REFUSAL OF PLANNING PERMISSION

APPLICATION NO. 2014/1230

**Proposal Erection of front porch extension to dwelling.
At 18 Windhill Mount, Darton, Barnsley, S75 5BW**

PROPOSED FRONT ELEVATION

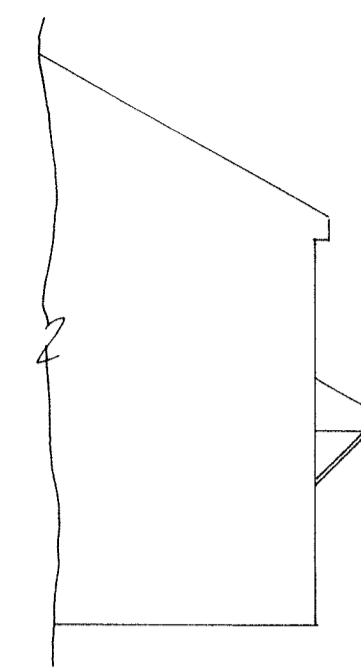
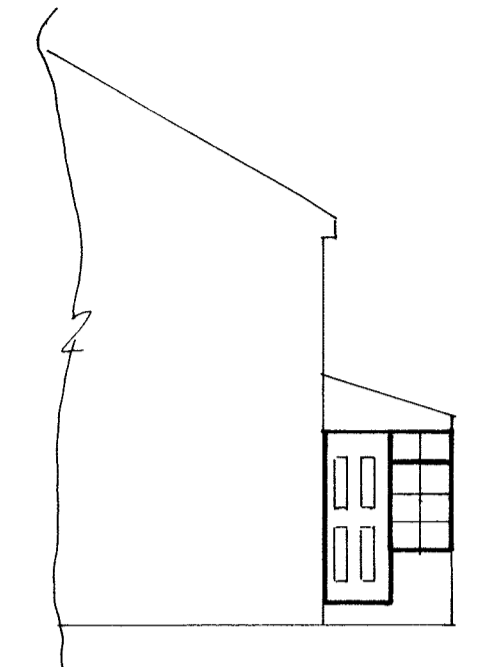
- 1 In the opinion of the Local Planning Authority the proposed front conservatory porch would be contrary to Policy CSP29 of the Core Strategy and the Council's Supplementary Planning Document, House Extensions and paragraph 64 of the NPPF. Its design and siting would be architecturally inconsistent with the character of the host property on this principle elevation and would as a consequence appear as an unduly intrusive and discordant feature. As such it would be detrimental to the visual amenities of the dwelling and the street scene.
